WEST SUSSEX COUNTY COUNCIL CONSULTATION

TO:	Arun District Council FAO: Richard Castro-Parker
FROM:	WSCC - Highways Authority
DATE:	23 August 2019
LOCATION:	Gladwyn, The Street, East Preston, BN16 1HT
SUBJECT:	EP/179/18/PL Demolition of existing house & erection of 3 x 3 bedroom houses together with landscaping, car parking and fencing. Amendment received.
DATE OF SITE VISIT:	n/a
RECOMMENDATION:	Advice
S106 CONTRIBUTION TOTAL:	n/a

Project: Proposed new homes; Gladwyn, The Street, East Preston BN16 1HT			
Drawing: Block plan, bin store elevations			
For: Mrs. J. Simmonds & Mr. P. Beamish			
Drawn: PKS		Date: November 2018	
Scales: 1:50 1:200		No: 2386/01/03/C	
To scale when printed on A3

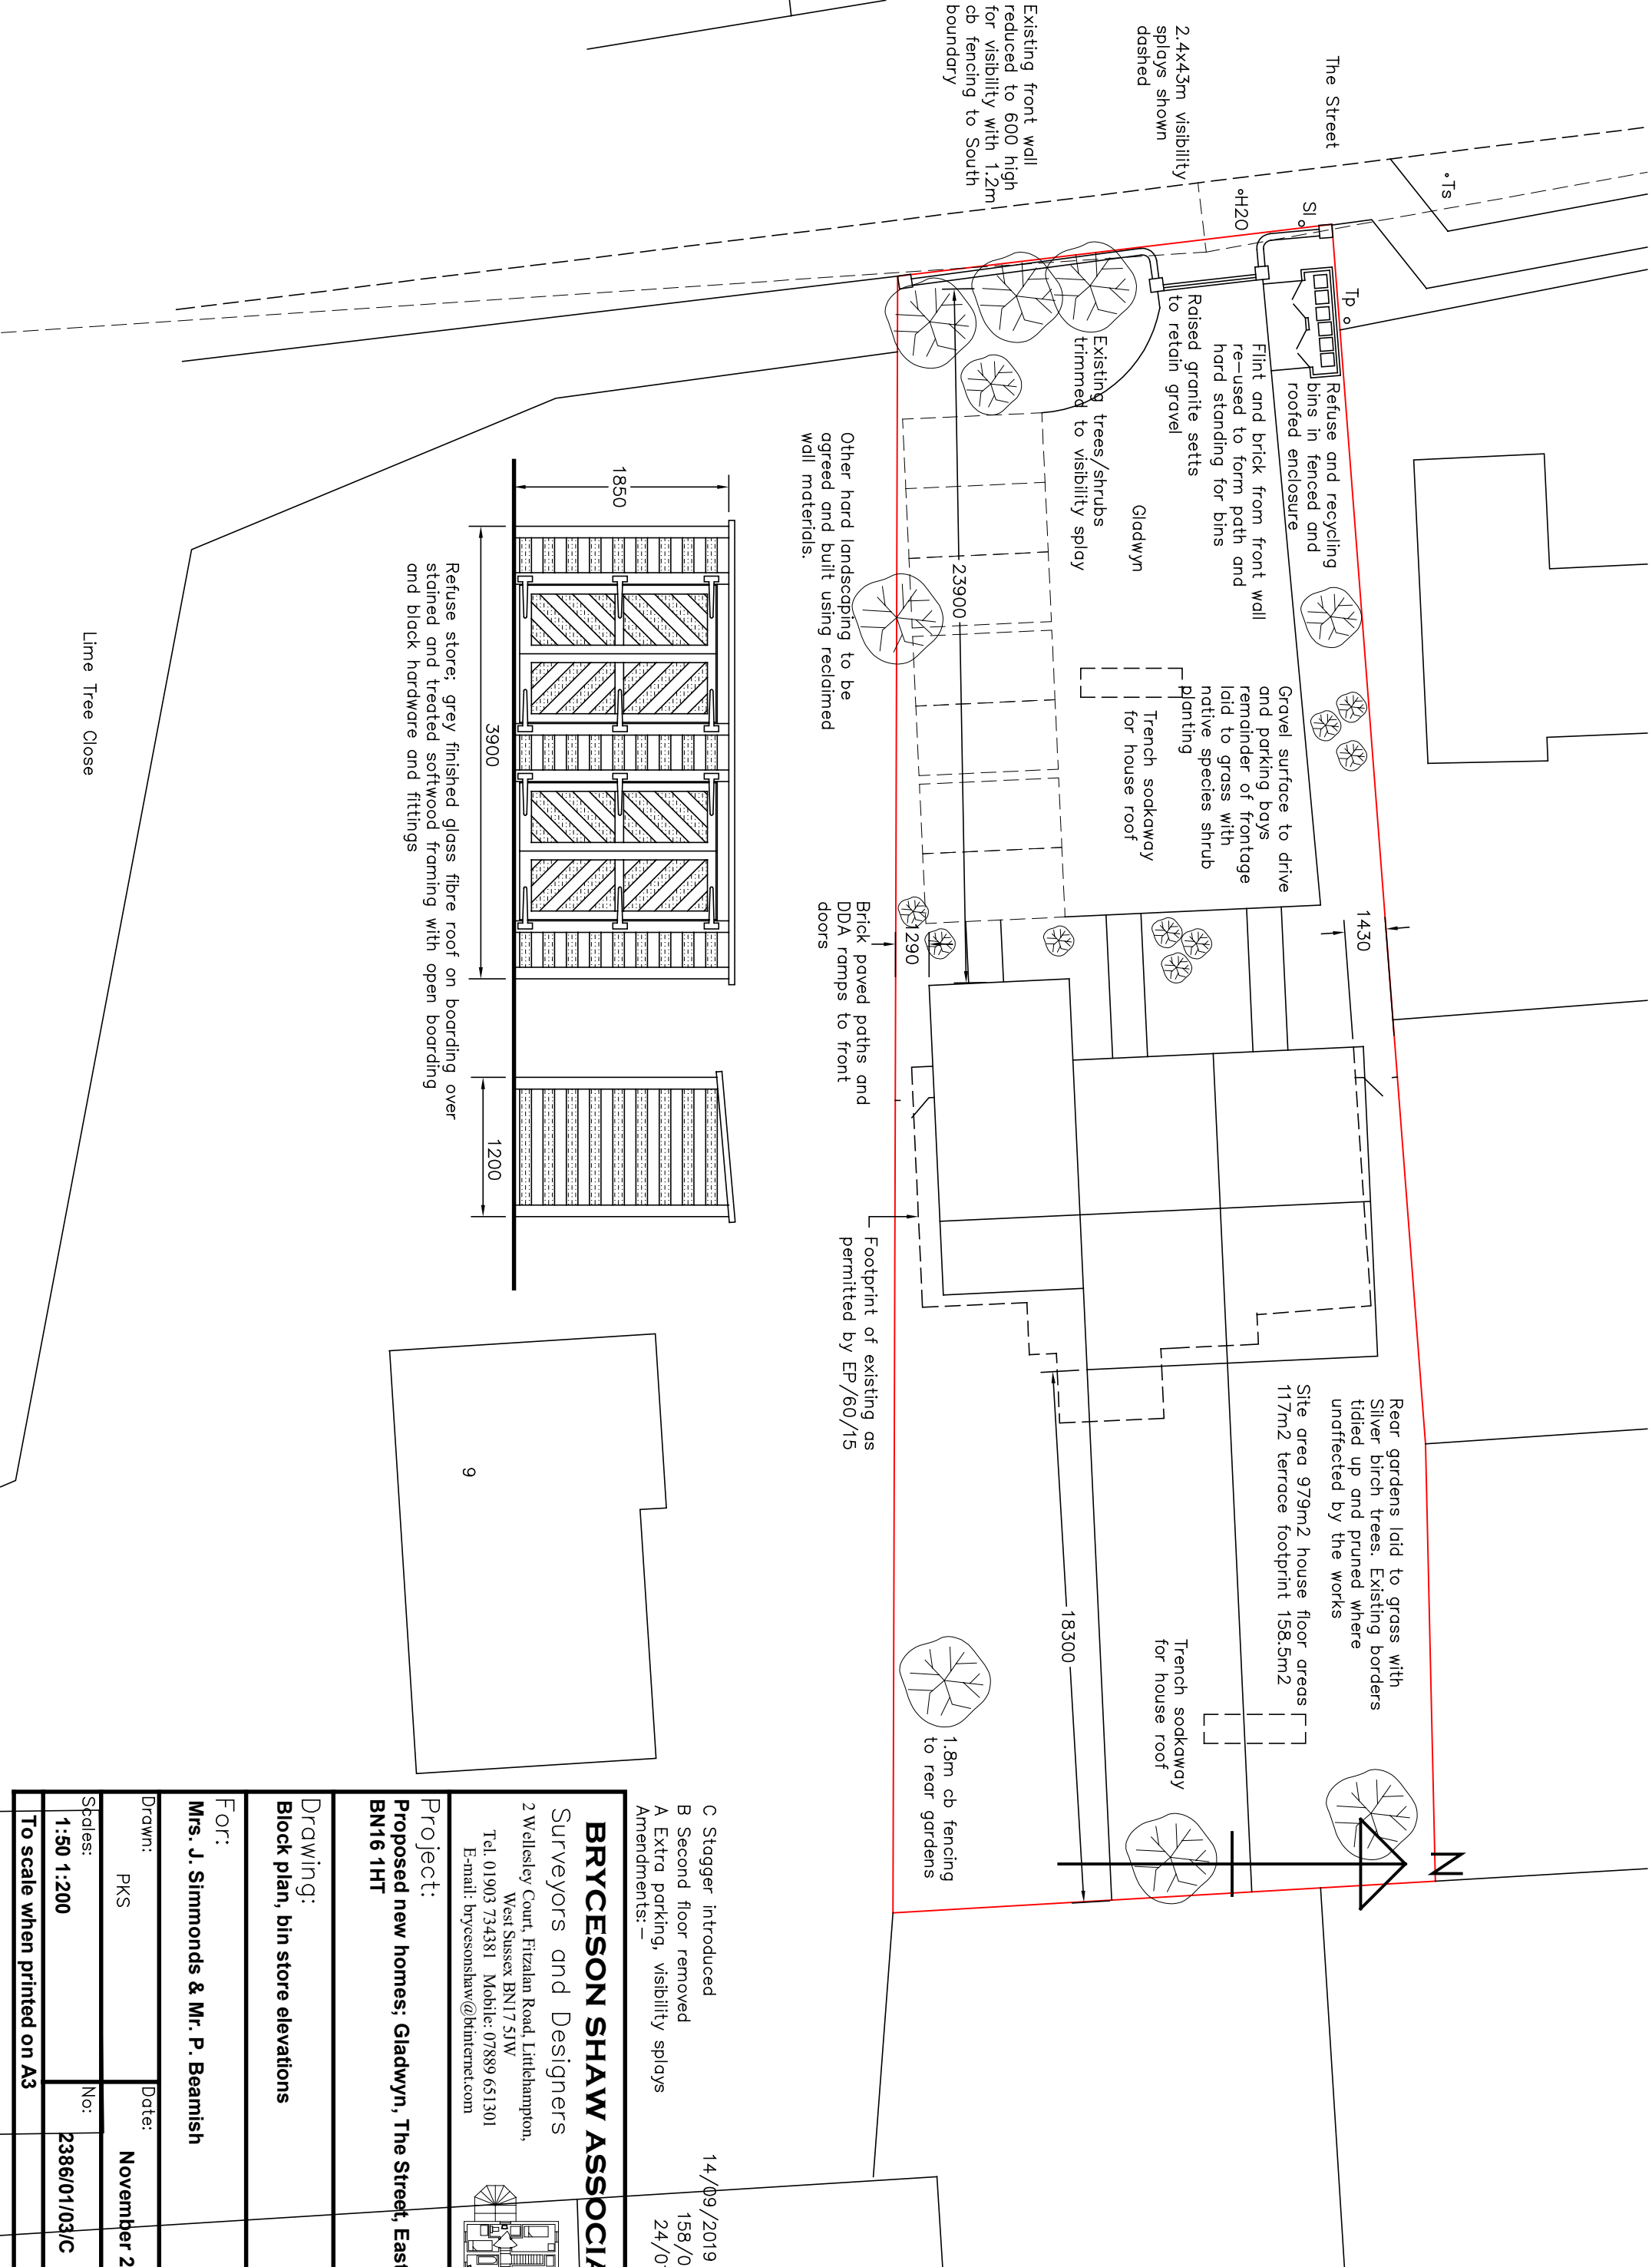
The proposed plans indicate that the existing 3.5m access will be utilised to serve the three proposed dwellings. The applicant may wish to consider widening the access to a minimum of 4.5m width to allow two vehicles to pass at slow speed. Any proposed access works would be subject to approval by the Local Highway Authority and subject to a licence from the Local Area Engineer.

The revised site plan demonstrates visibility splays at the existing access. Whilst the plan has been annotated stating that 2.4 x 43m splays are achievable, the plan does not demonstrate the full extent of the splays in either direction. A plan demonstrating the full extent of splays can be secured via condition. The applicant has clearly indicated that the existing boundary wall either side of the access will be reduced in height to a maximum of 0.6m within the proposed splays.

The revised plans indicate that a total of six parking spaces will be provided for the three dwellings. Since the LHA's previous response to this application in January 2019, the WSCC Parking Guidance has been updated. The WSCC Parking Demand Calculator (updated August 2019) anticipates that a minimum of 7 parking spaces would be required if spaces remain unallocated. If spaces are to be allocated at 2 per dwelling, a minimum of 9 parking spaces will be required to allow for visitor and additional parking. The LPA may wish to consider the potential impacts of this development on on-street parking from an amenity point of view. Each space meets minimum specifications of 2.4 x 4.8m as set out in Manual for Streets (MfS). There appears to be sufficient space on site for vehicles to turn and exit onto the publicly maintained highway in a forward gear.

No part of the development shall be first occupied until visibility splays of 2.4 metres by 43 metres have been provided at the proposed site vehicular access onto The Street in accordance with plans and details to be submitted to and approved in writing by the Local Planning Authority. Once provided the splays shall thereafter be maintained and kept free of all obstructions over a height of 0.6 metre above adjoining carriageway level or as otherwise agreed.

No part of the development shall be first occupied until the car parking has been constructed in accordance with the approved site plan. These spaces shall thereafter be retained at all times for their designated purpose.
